April 11, 2016
14164

Subdivision and Site Plan Application/ Submittal No. 2
62 India Street, Portland, Maine

RESPONSES TO COMMENTS FROM DAVID SENUS' MEMO DATED MARCH 28, 2016 :

1000 GALLON GREASE TRAP
NOT TO SCALE

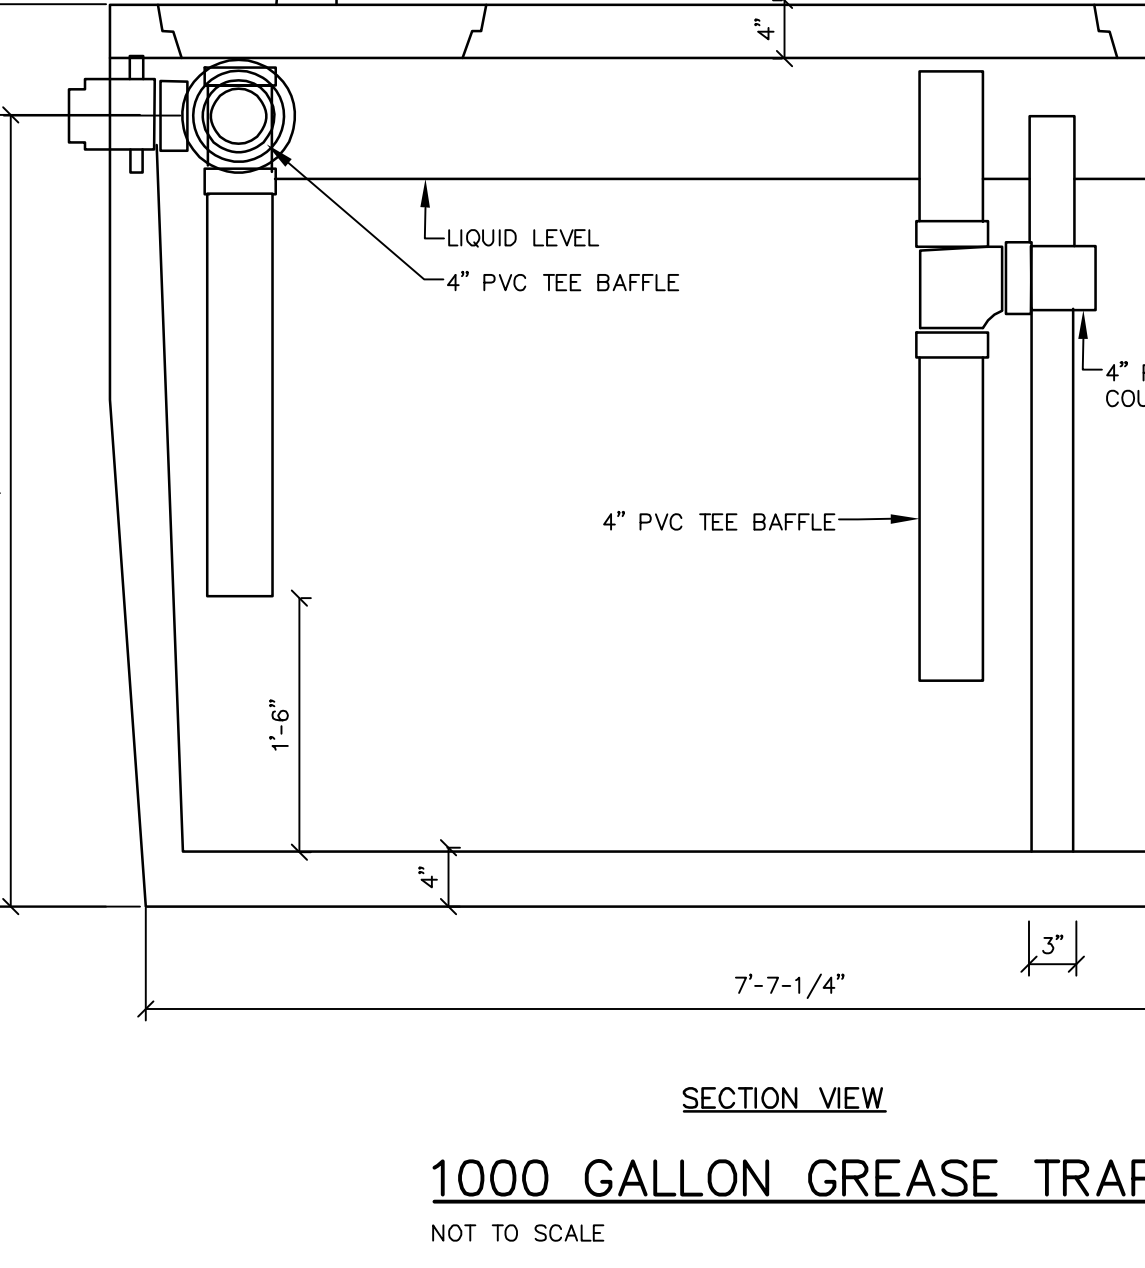
1. The applicant has no specific tenant(s) for the retail space(s), however, is confident that the proposed 1,000 gallon grease trap will be sufficient. If and when a tenant requiring a grease trap is identified, we will consult with Rachel Smith as suggested.

PRECAST SEWER MANHOLE
NOT TO SCALE

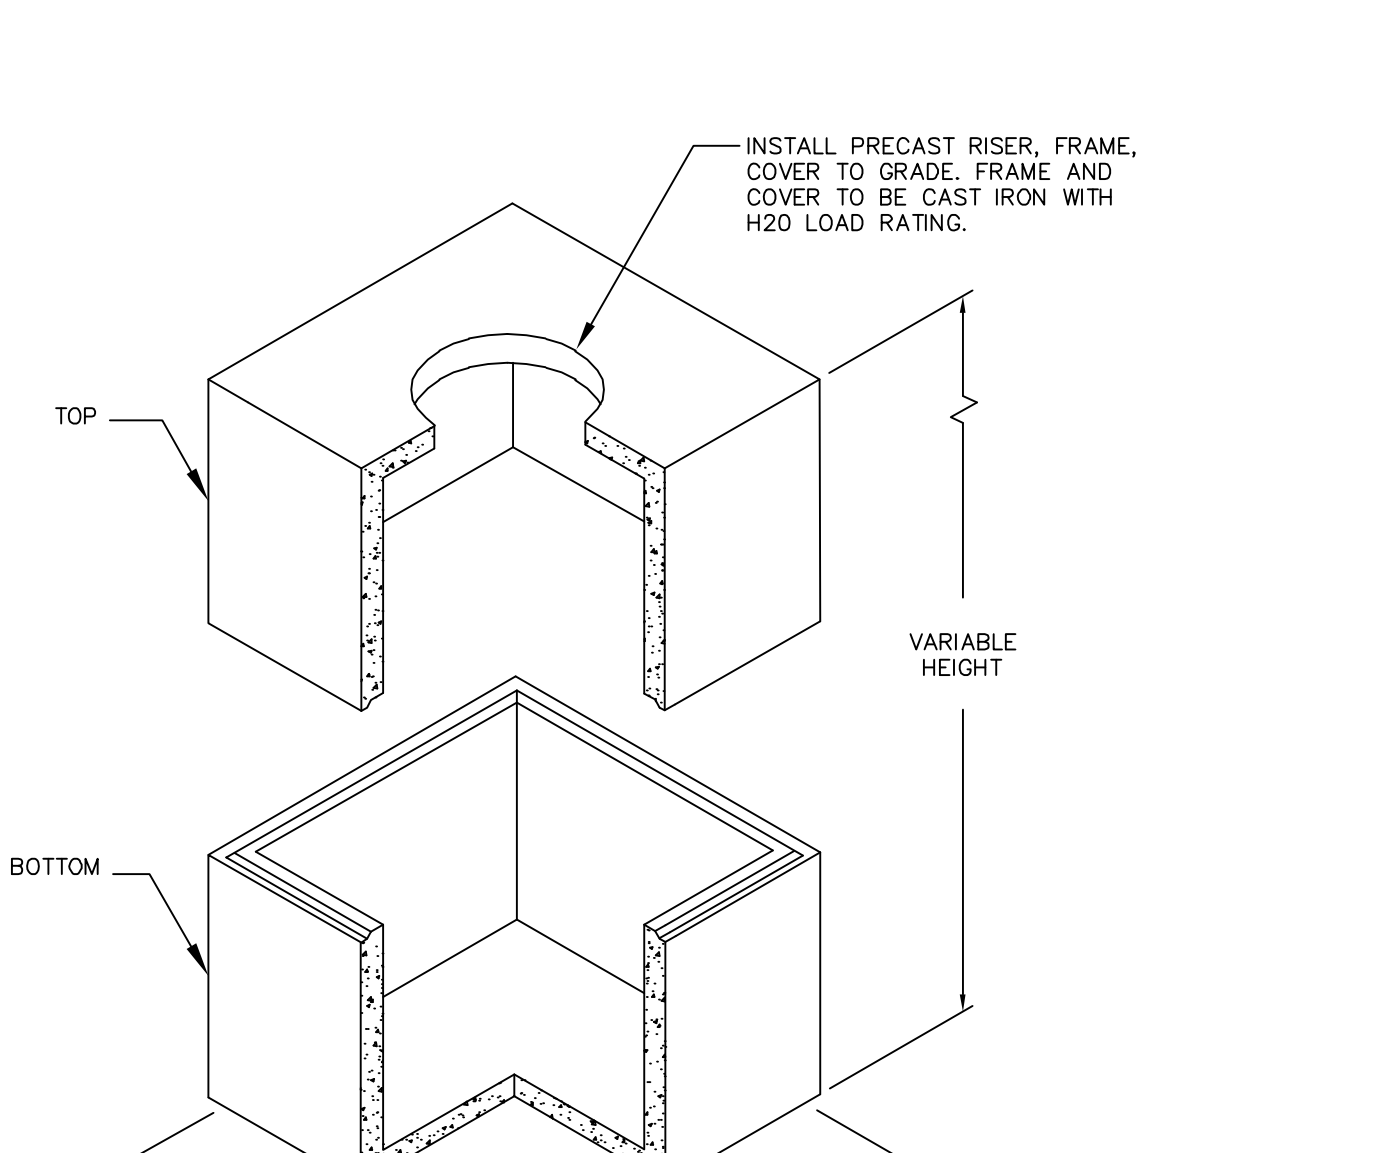
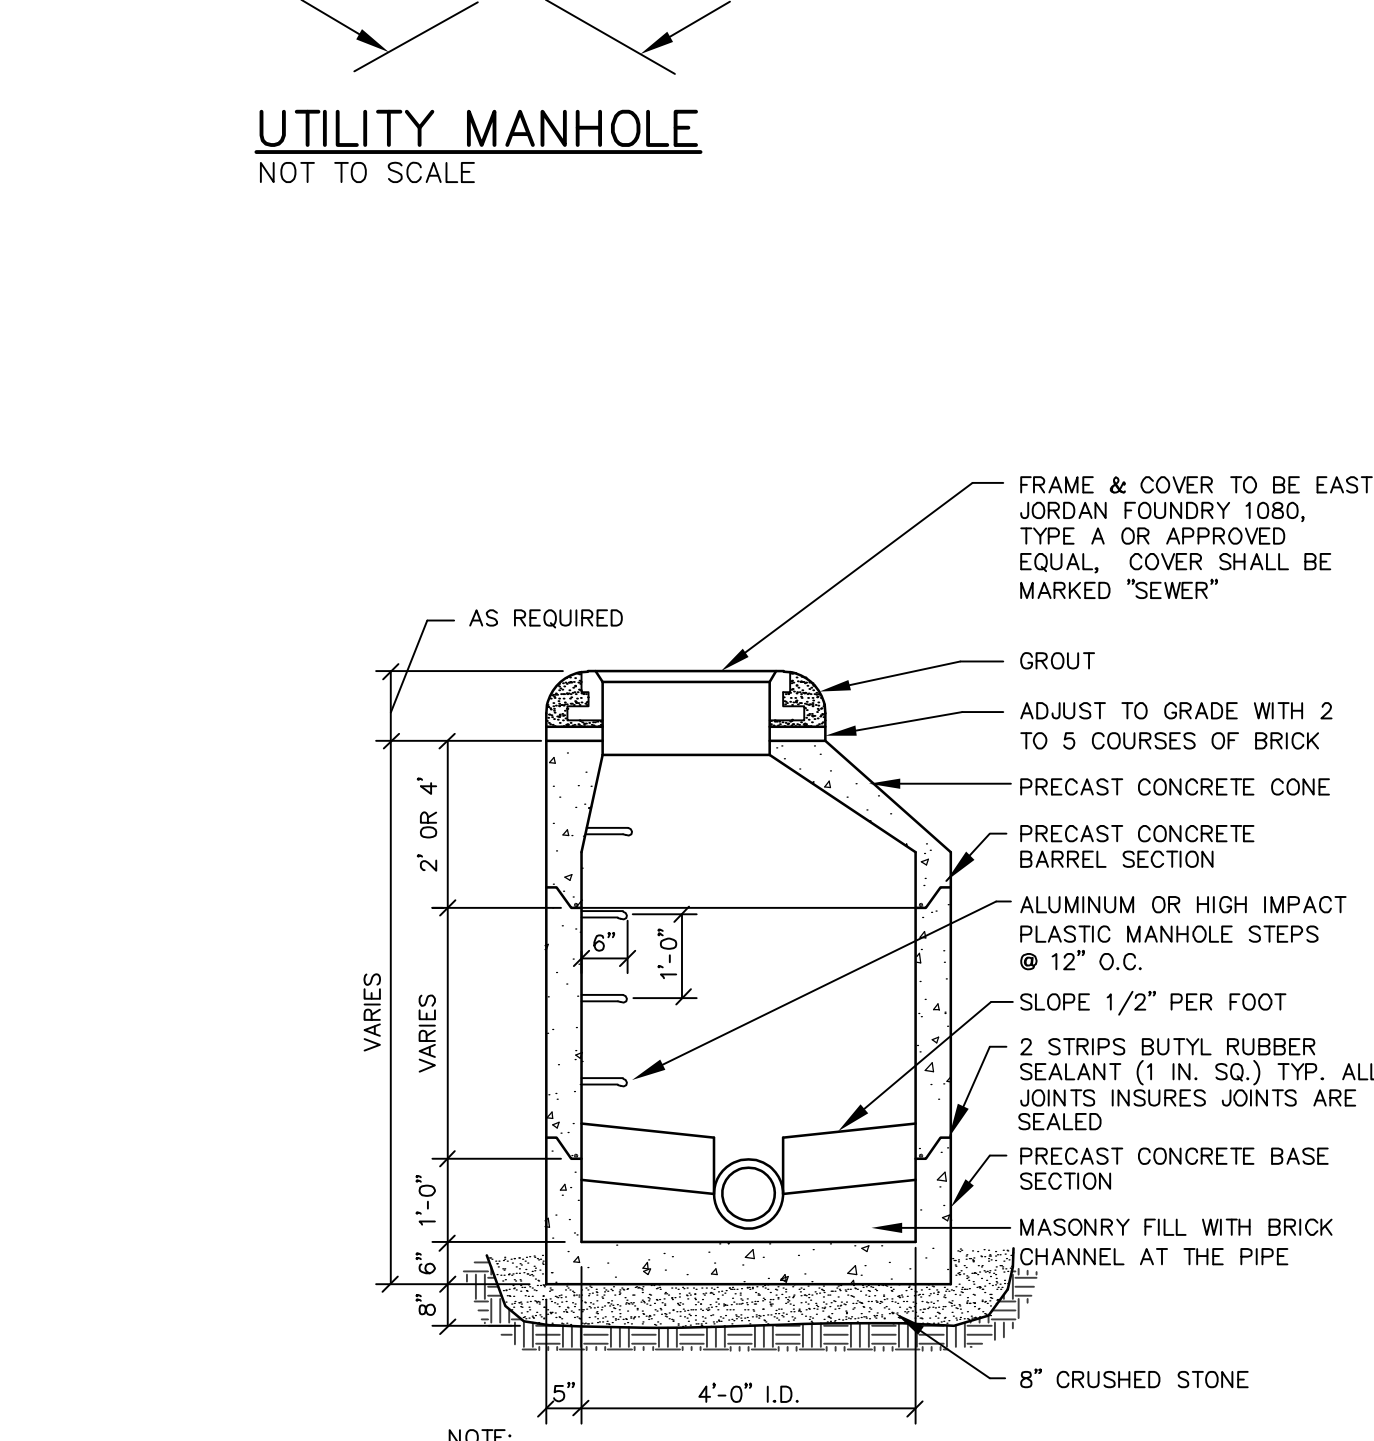
- 7) A sewer manhole has been added at the proposed sewer connection in India Street.
- 8) The drainage structure within the garage areas has been revised to an oil/ grit separator per detail provided by the City.

2. A sewer manhole has been added where the building is connected to the India Street sewer main.
3. Plans have been stamped by a professional engineer.

OIL / GRIT SEPARATOR
NOT TO SCALE

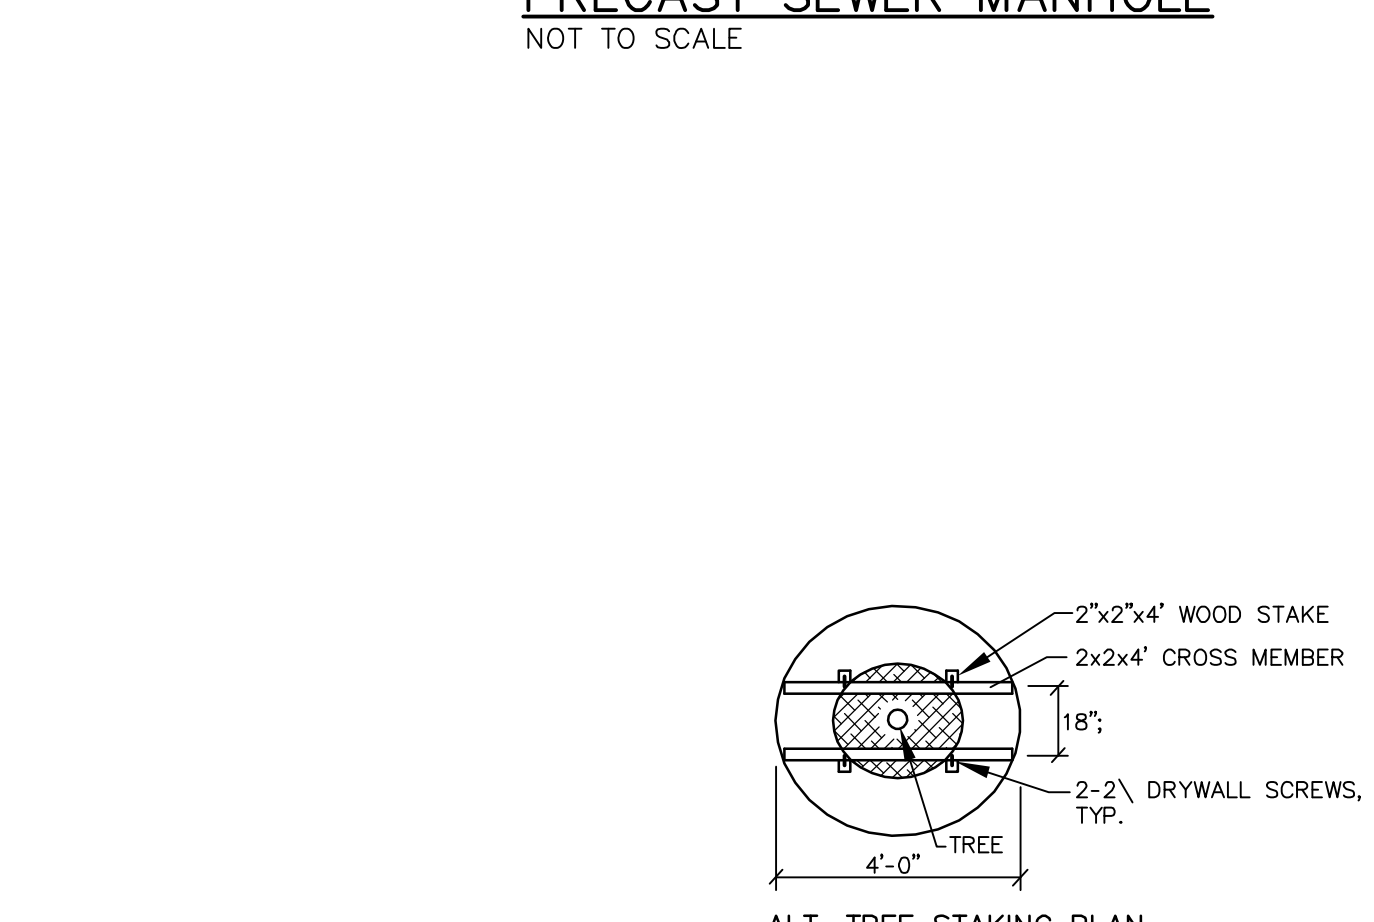
11. The catch basin in the garage has been replaced with an oil / grit separator, with the detail provided by the City.
12. The catch basin at the corner of India and Newbury has been shifted so as to not conflict with the proposed sidewalk ramp. Rather than trying to salvage and re – use the existing basin, we are proposing a new catch basin structure in this location.
